EPC STORMWATER REVIEW COMMENTS  
 IN ORANGE BOXES WITH BLACK TEXT

## EL PASO COUNTY GRADING AND EROSION CONTROL PLAN CHECKLIST

EPC Project Number: **VR2323**

**SITE & UTILITY  
PLAN**

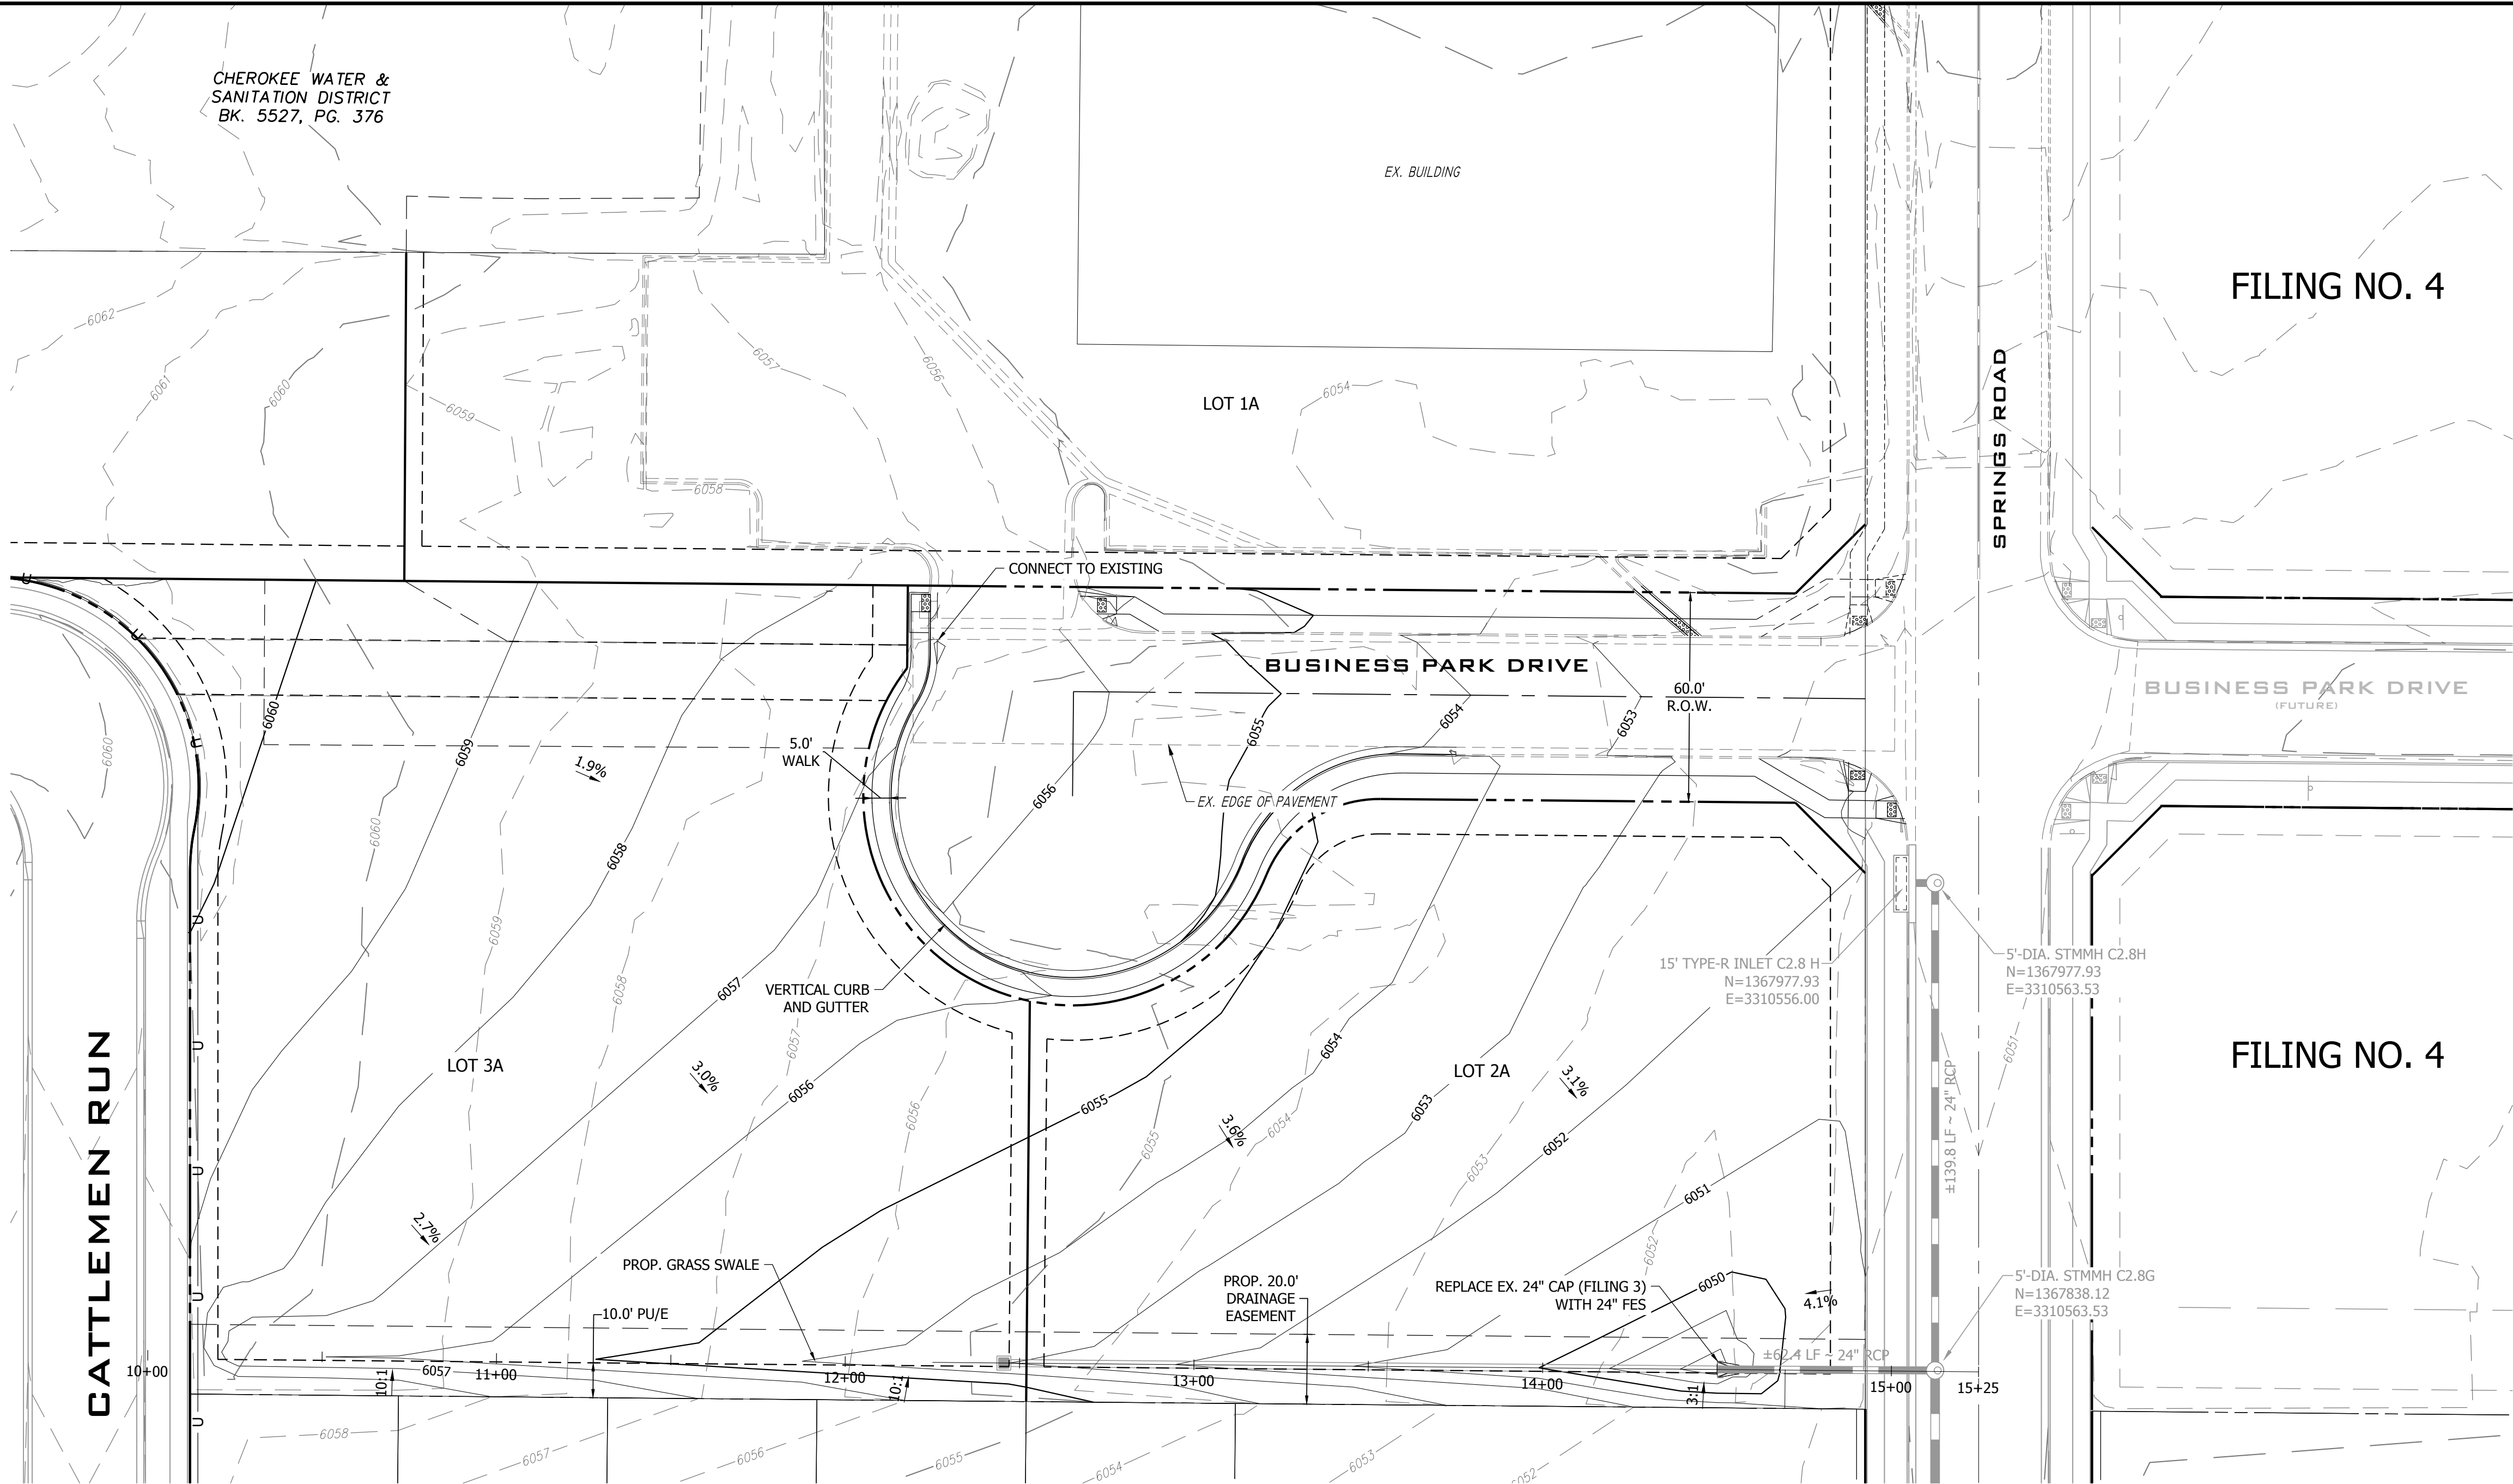
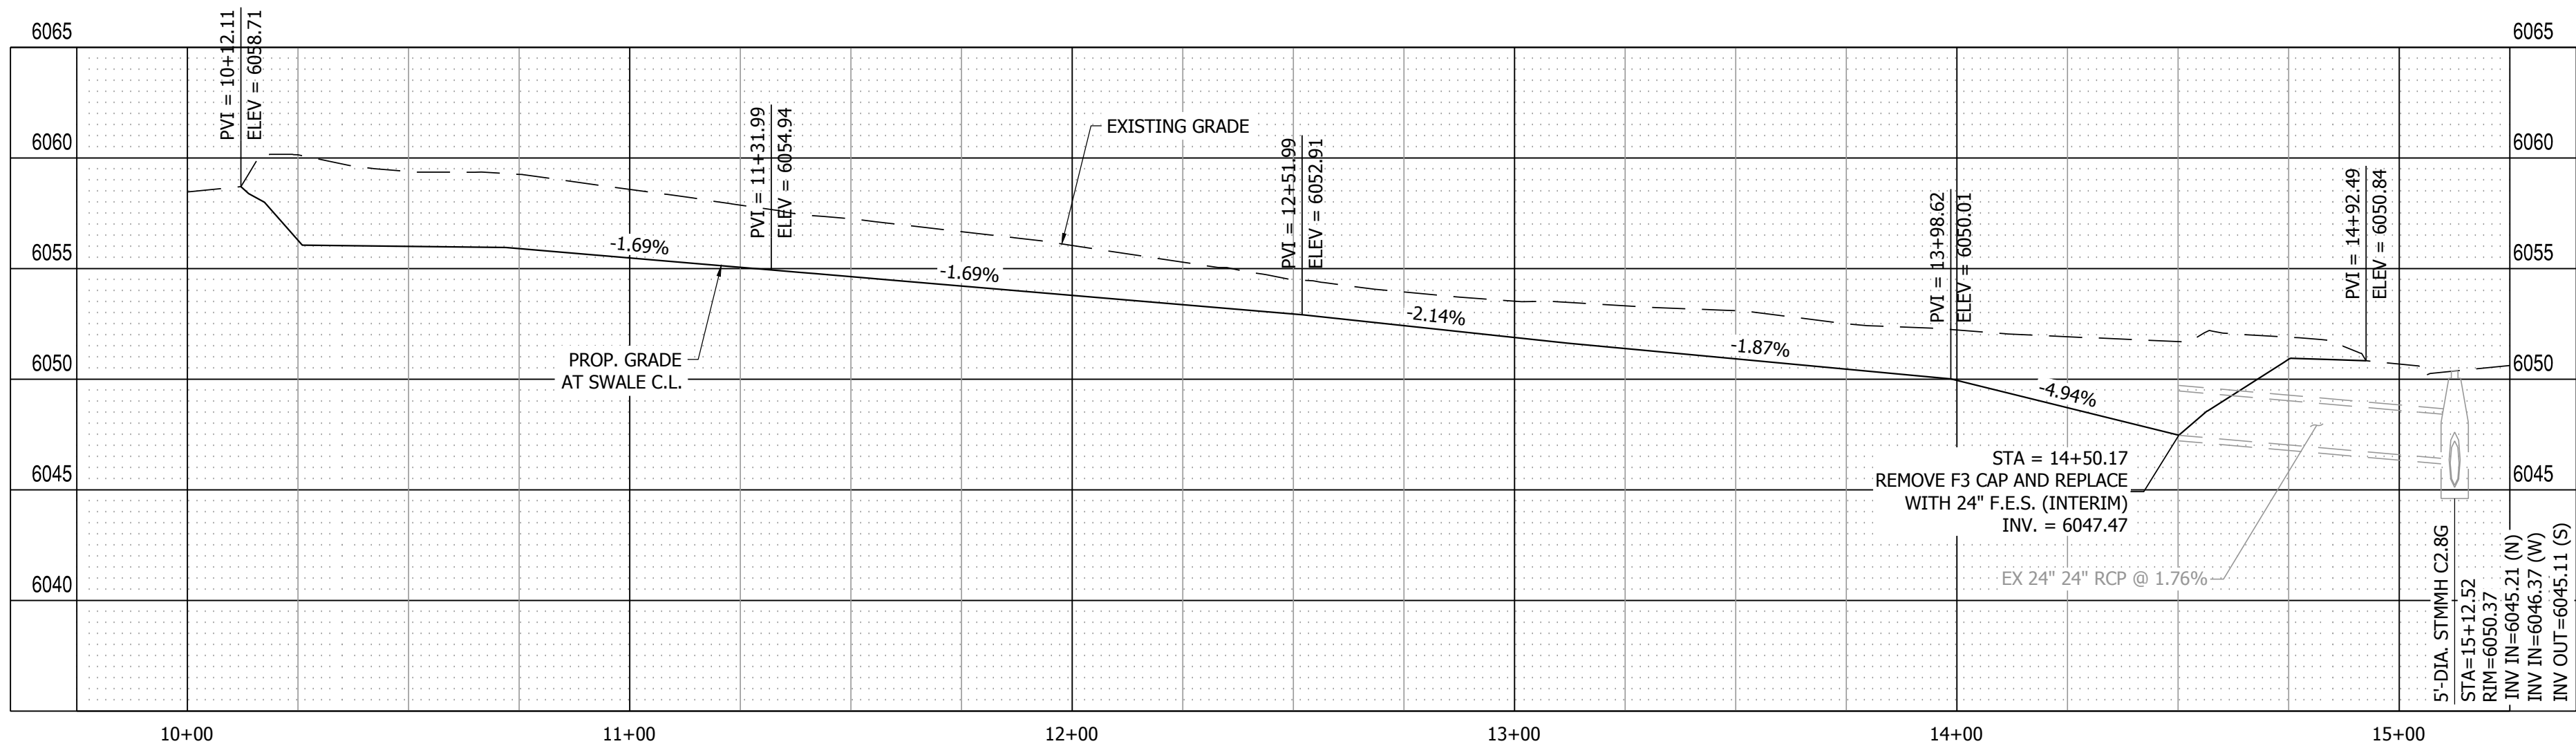
Verify. Y is selected, but there is no obvious off-site grading. If applicable clearly delineate and label as off-site grading. Or put N/A if not applicable.
